RE: SUBMISSION ON DART + WEST ON BEHALF OF SPENCER PLACE DEVELOPMENT COMPANY LIMITED

ABP Ref. NA29S.314232

Description - DART+ West Railway Order - Dublin City to Maynooth and M3 Parkway

Scale:  
1:200 @ A1 - 1:400 @ A3

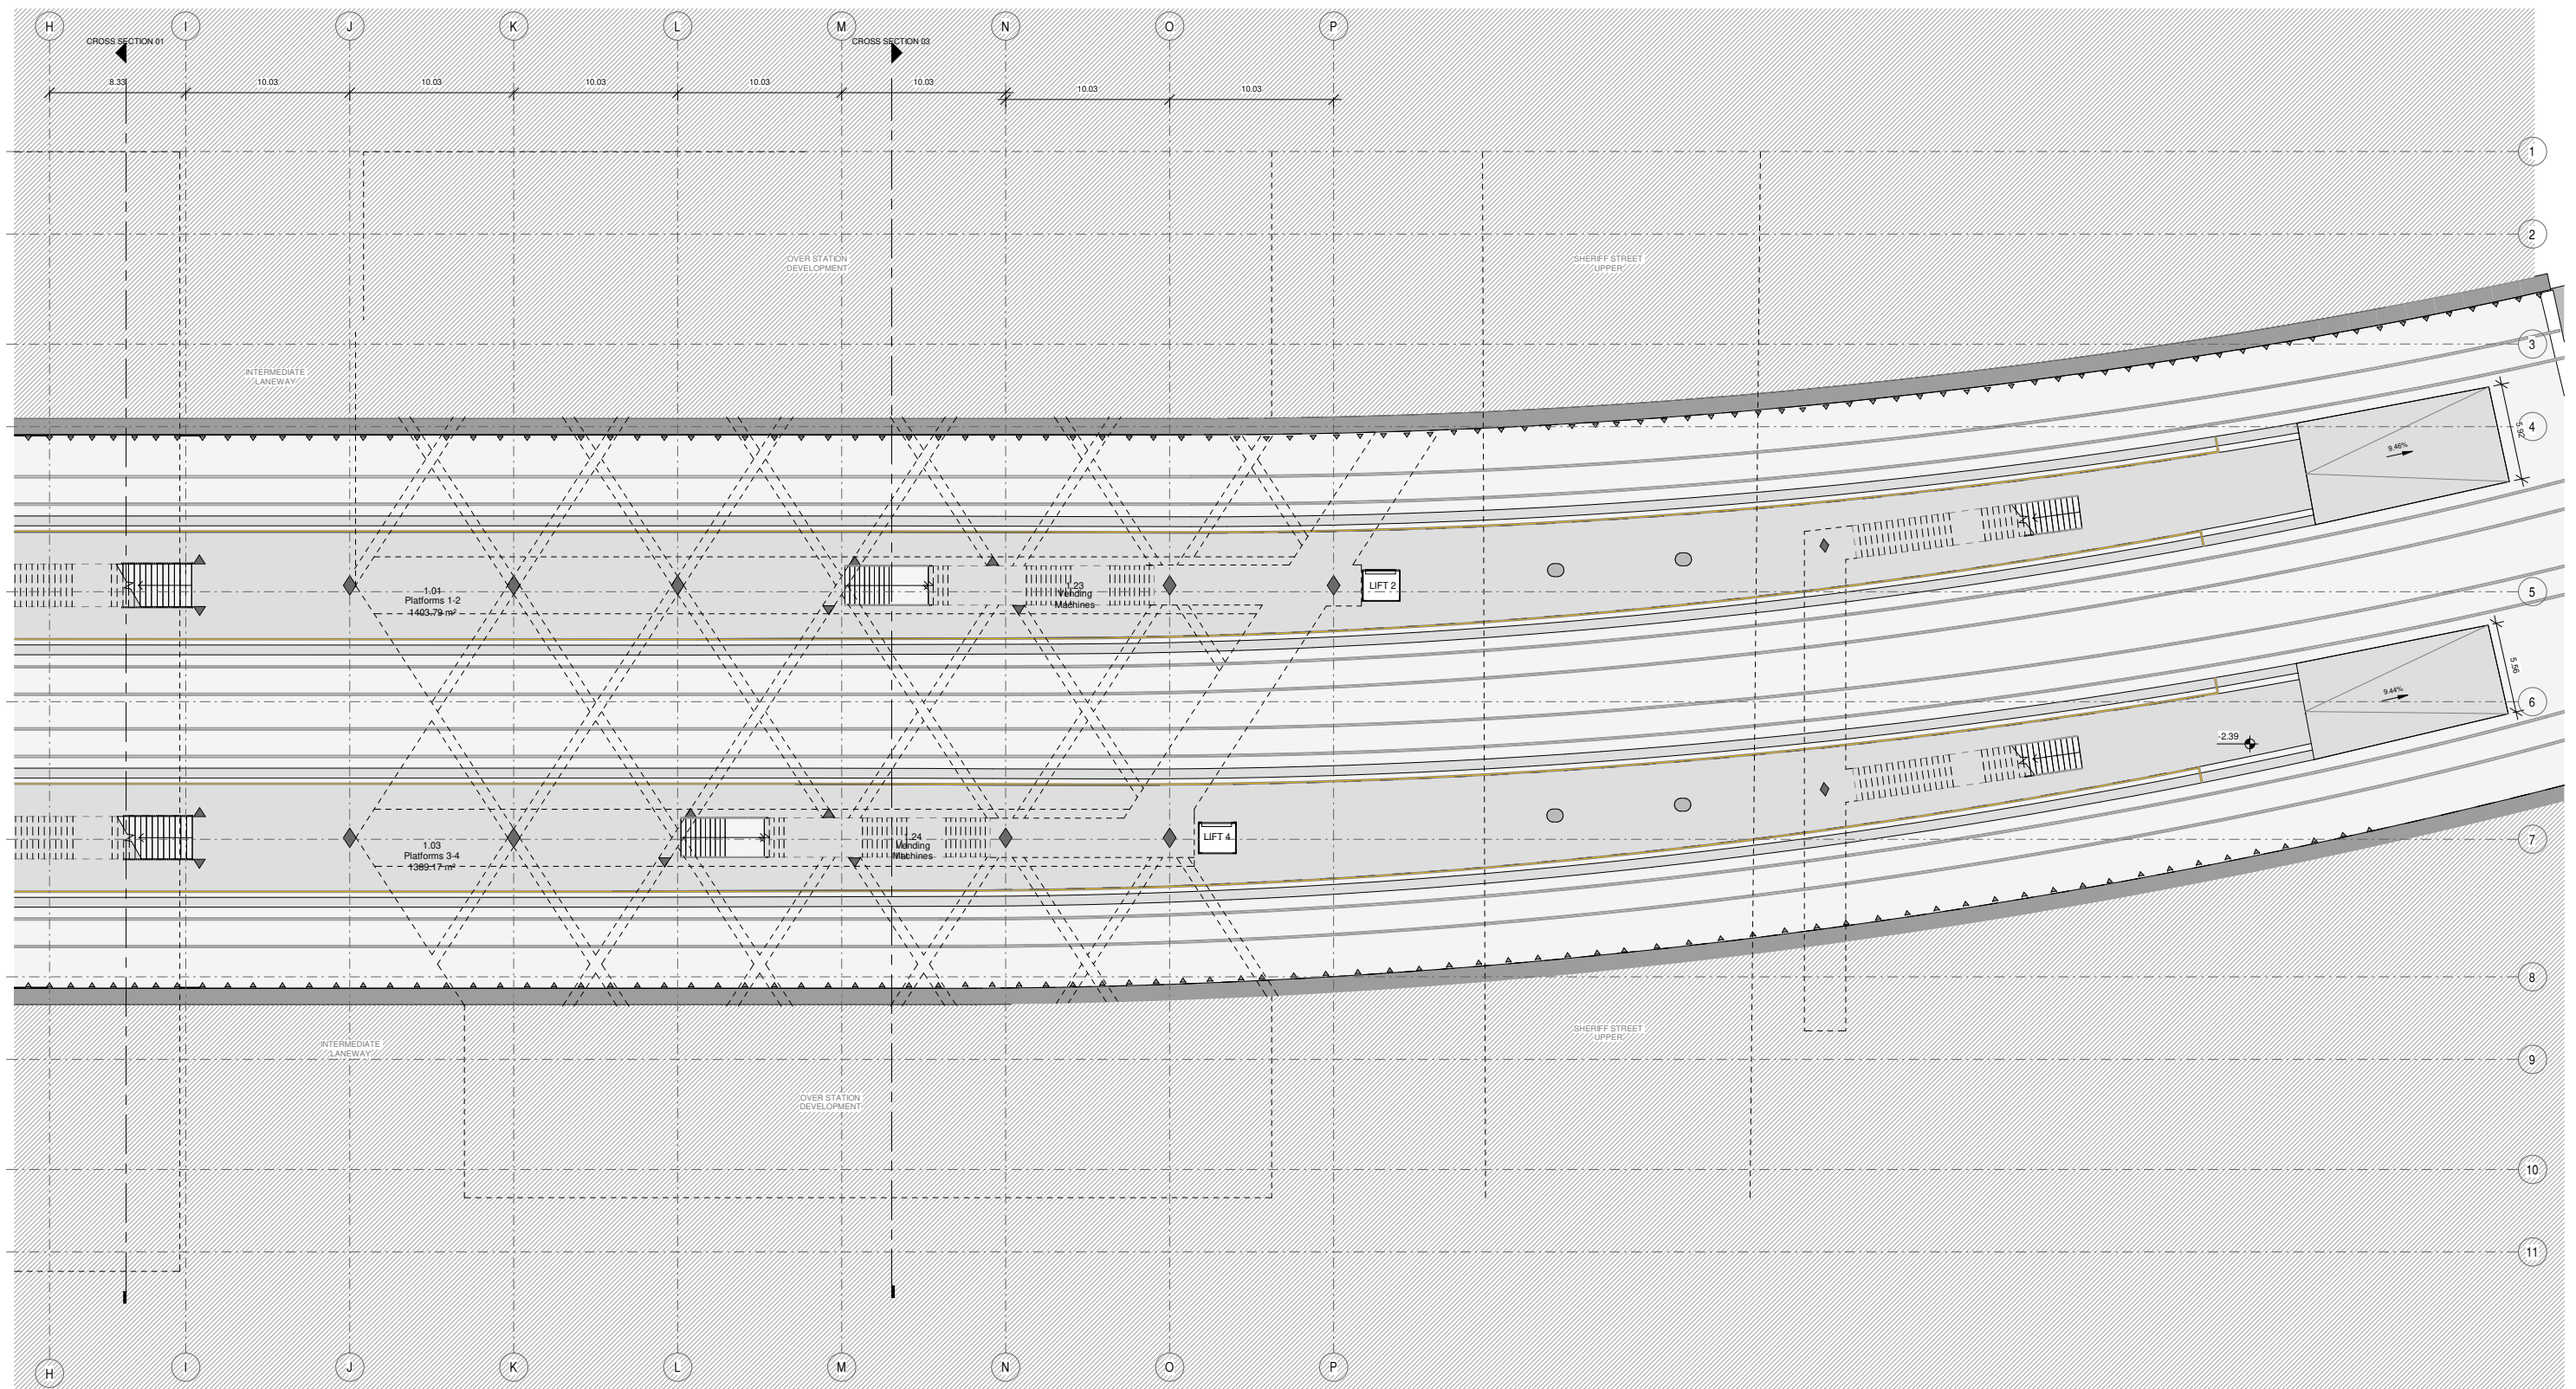
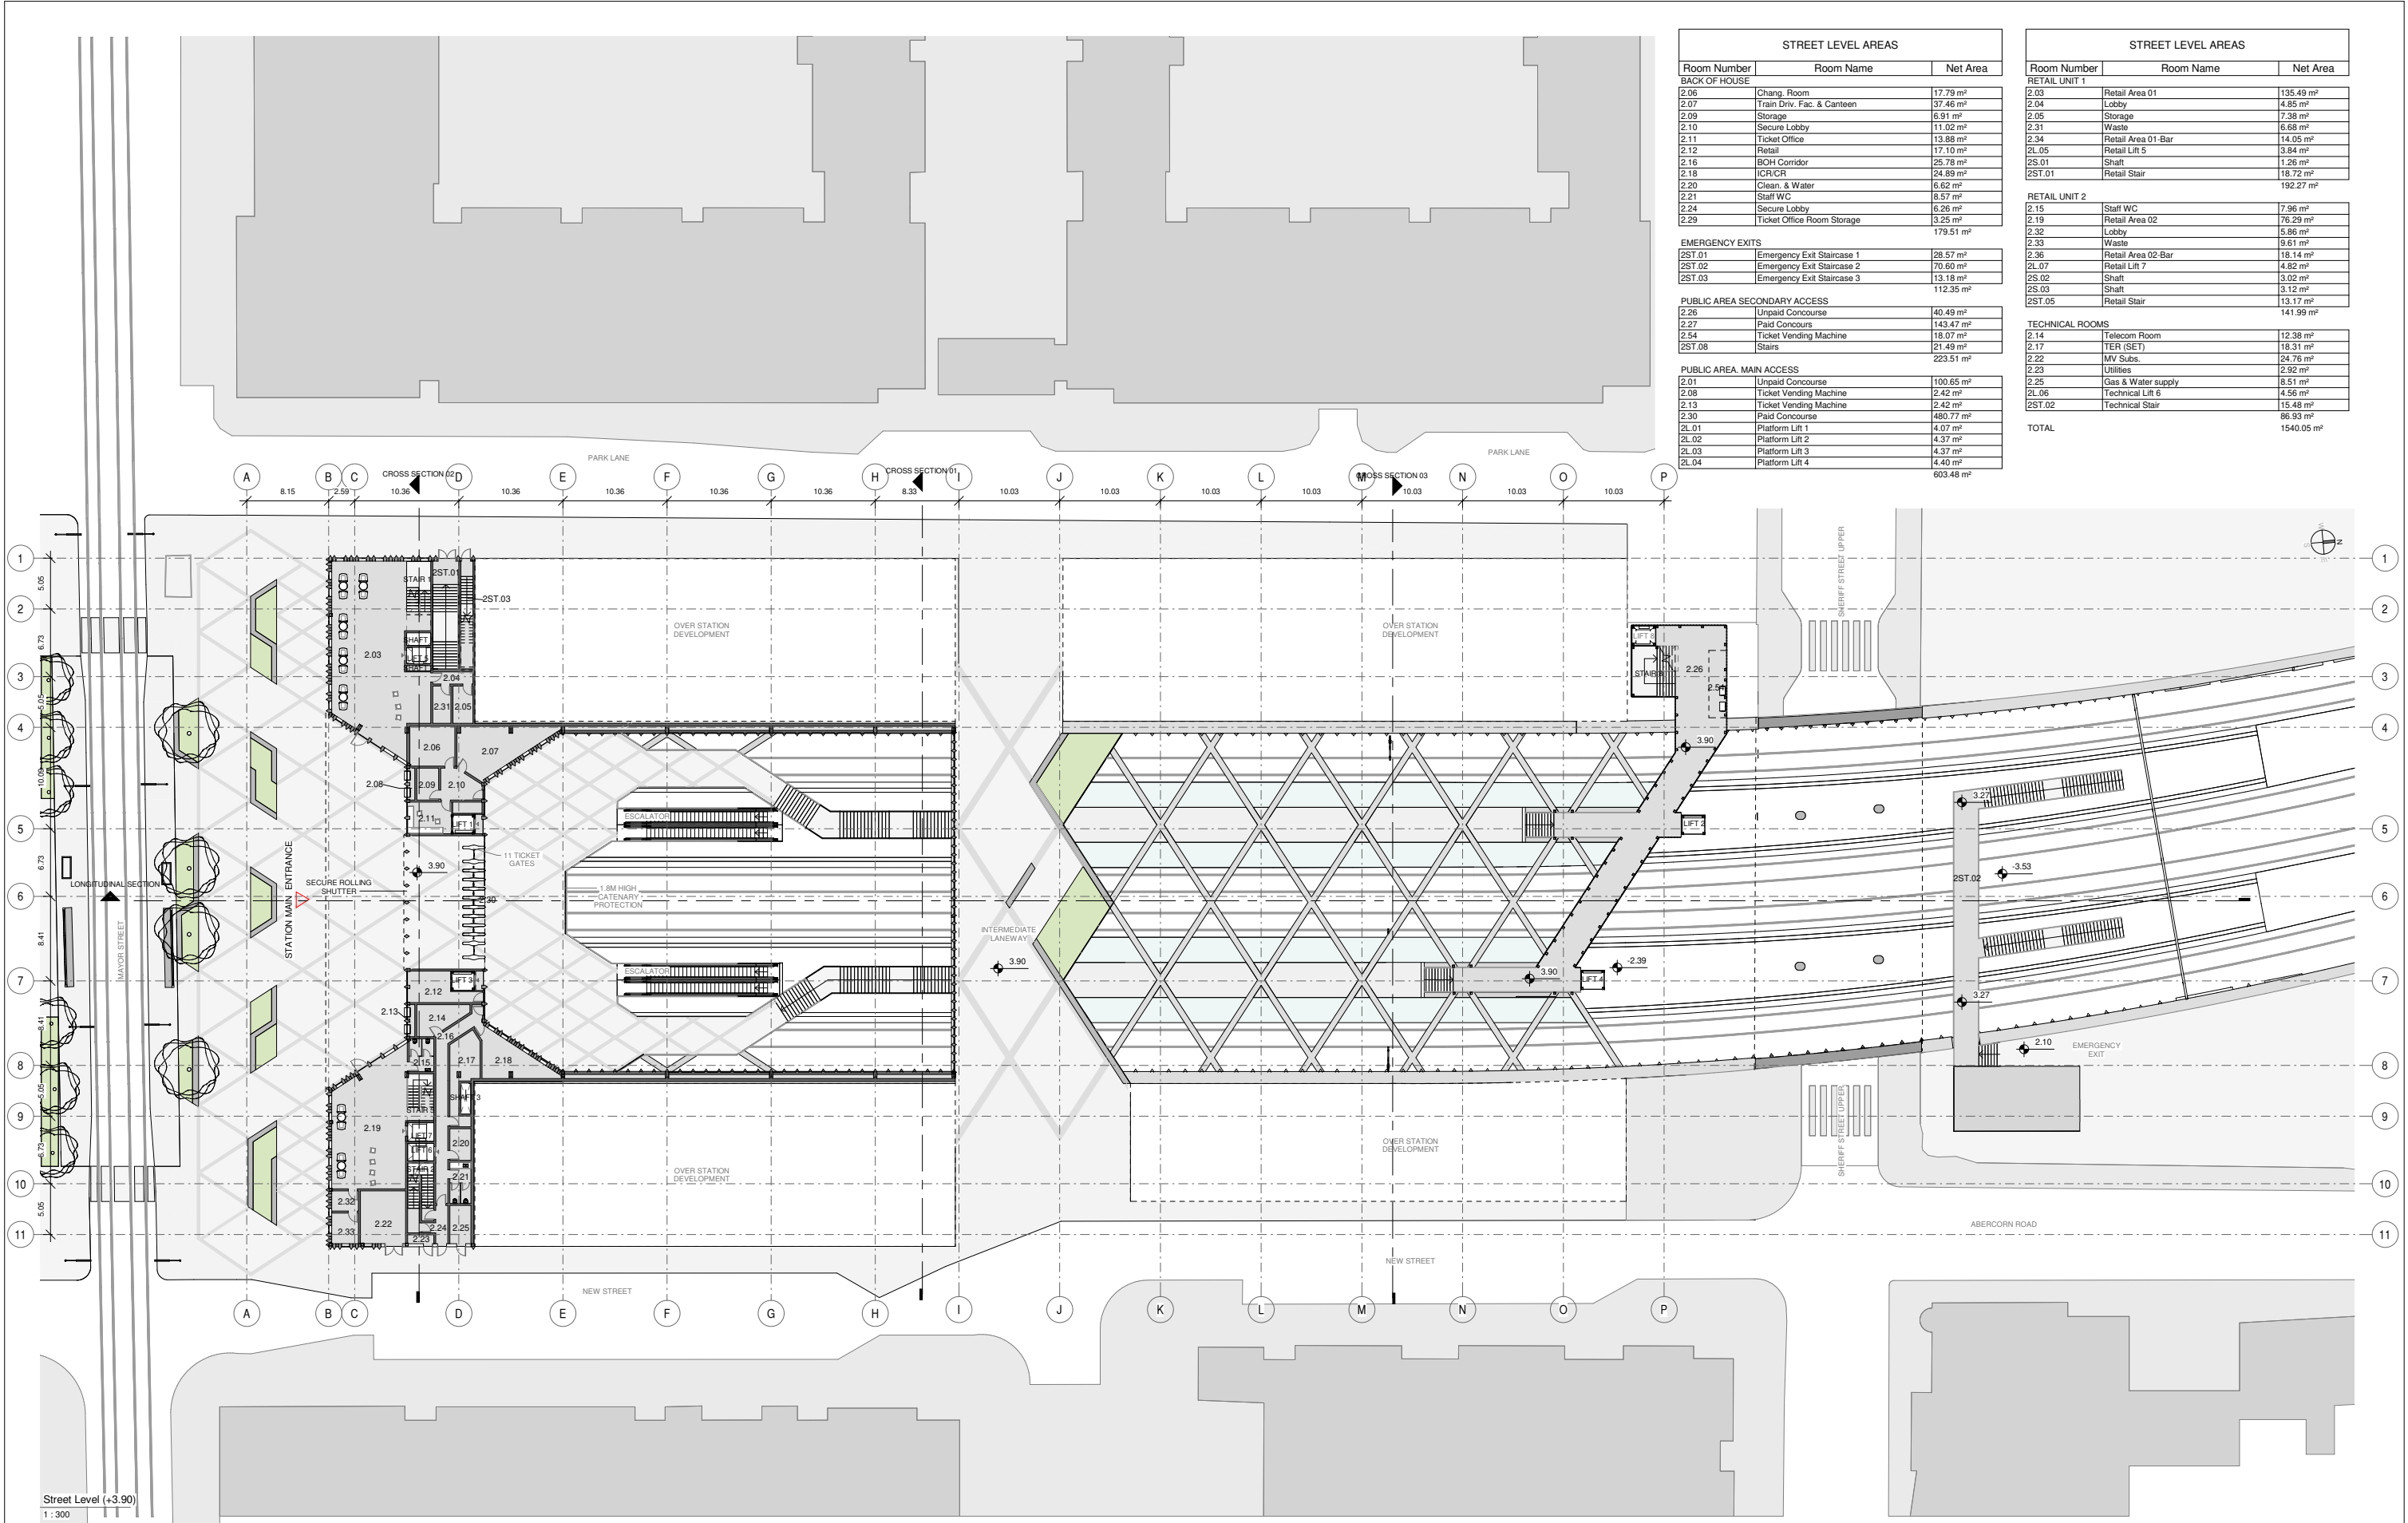
Our client also wishes to highlight the difficulties in assessing the proposals from the documentation submitted. The drawings relevant to Spencer Dock, do not show separation distances, or the dimensions of areas proposed for temporary and permanent land take. Furthermore, it is not clear from the information submitted, the purpose of the temporary land acquisitions and the nature and arising restrictions of permanent subterranean acquisitions. Our client would welcome further information in this respect, and an opportunity to further comment.

There is therefore clear provision in the statutory Planning Scheme for a 6 storey commercial / 7 storey residential development on the location of our clients lands in Block 2A, permissible on confirmation of the location of the station. The applicant's drawings and Spencer Dock Station Design Report show a notional future over station development for Spencer Dock. Detail is provided as to how Block 2C may be developed; however, no such detail is shown for Block 2C, which is partly in our client's control.

Our client seeks further information from the applicant to demonstrate that the design of the Spencer Dock Station incorporates the required elements to facilitate future over station development, both on our client's land interest and as part of a wider more comprehensive approach to an over station development at Block 2C. If such provisions are not incorporated at this stage, the proposals may prevent such appropriate future development, contrary to the provisions of the Planning Scheme.

Further, clarity is required on the nature of the subterranean acquisition to the east of the station building, and the restrictions on subterranean works which would facilitate over station development or development adjacent the station. This is considered essential to enable the Board to properly address whether the proposed scheme the subject of the Railway Order application can be considered to be consistent with the proper planning and sustainable development of the area.

Cross Section 01  
1:200

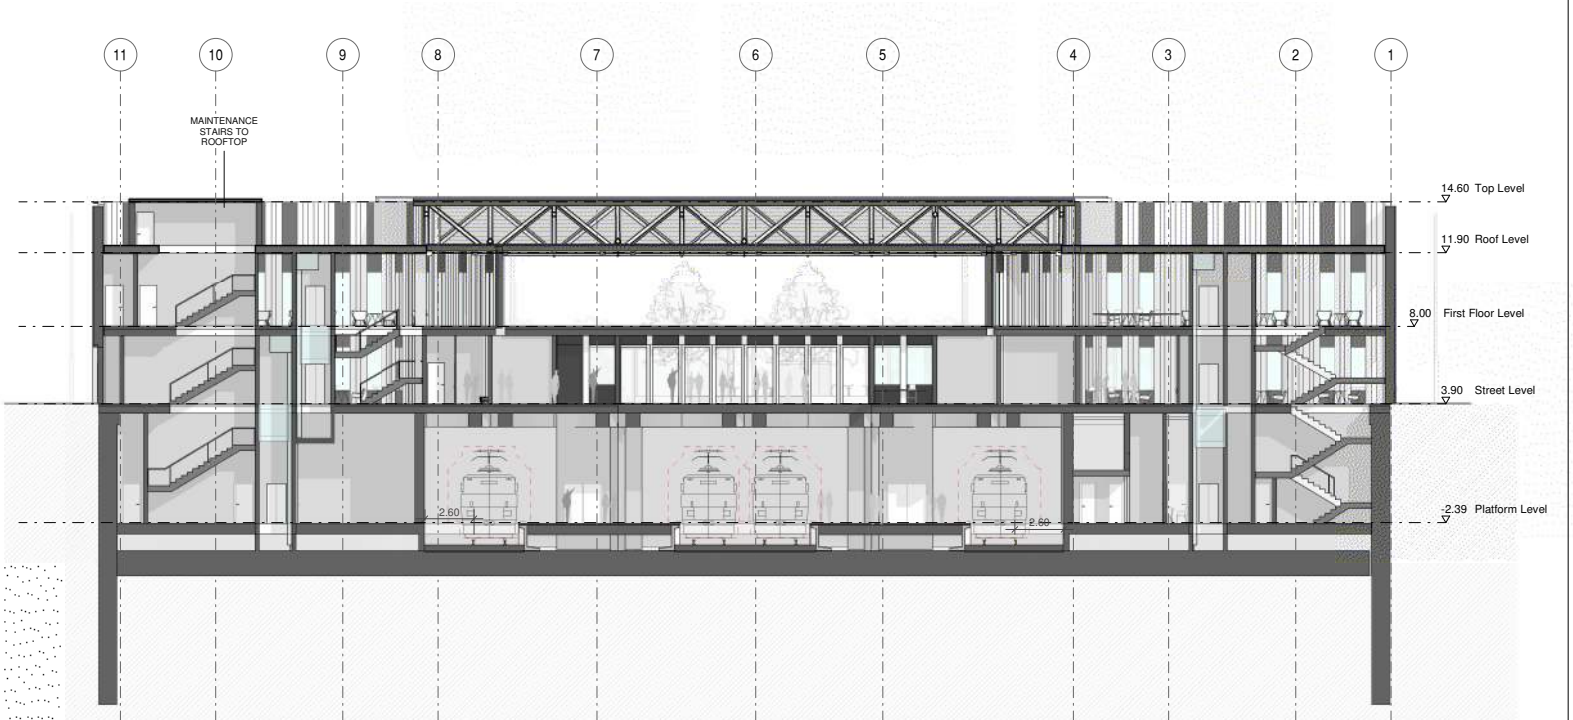
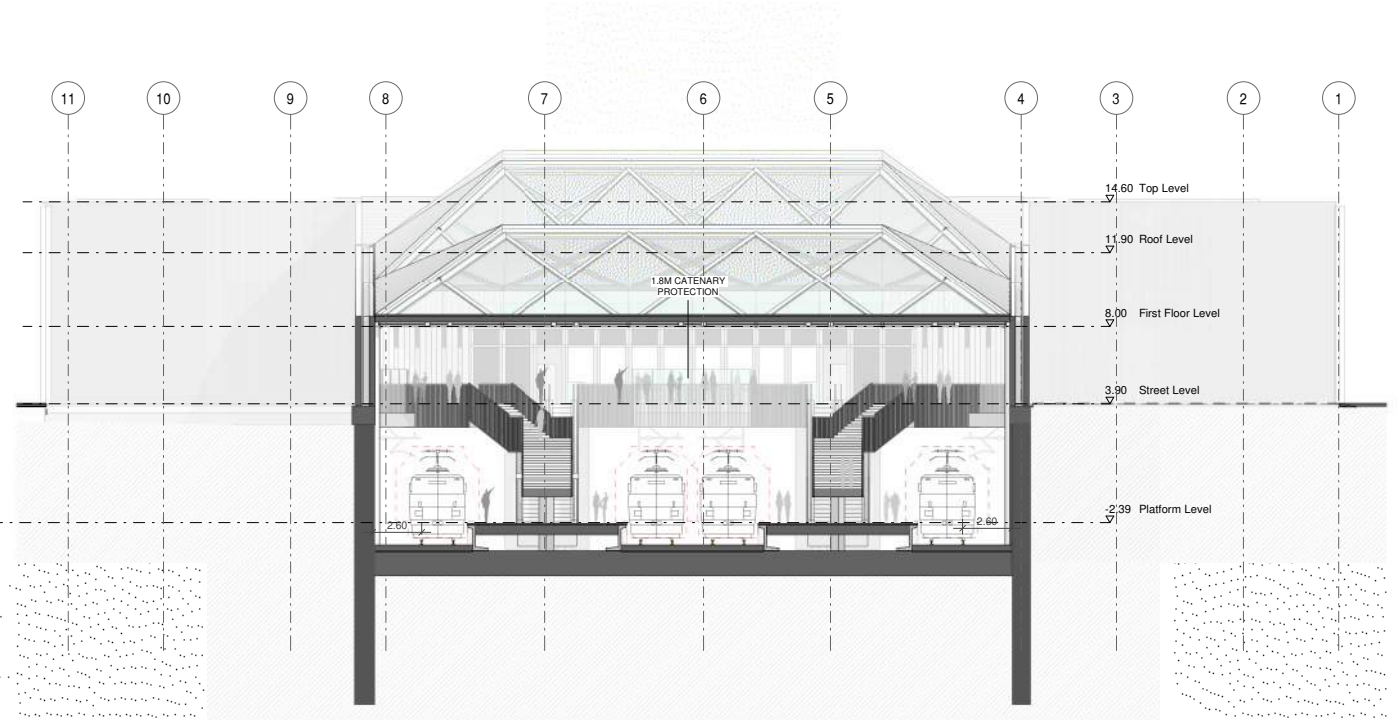
1. *What is the programme for delivery of the rail works? Could the over-station development progress in advance of the rail works?*
2. *What extent of over-station development is currently envisaged?*
3. *Single block either side of the tracks or is an air-rights development spanning over the tracks considered?*
4. *The proposed permanent sub-surface land take (ref DW.002.S.08(A)) is under the noted "over station development" on the Dart+ West plans – how are foundations/basements/sub-floor drainage/etc for an over-station development to be facilitated in a permanent sub-surface land take?*
5. *If an air-rights development, over the tracks, was considered feasible with a view to maximising density of development at transport hubs, can permanent support structure be incorporated into the track alignment design – subject to detailed consultation with Iarnród Éireann Irish Rail?*
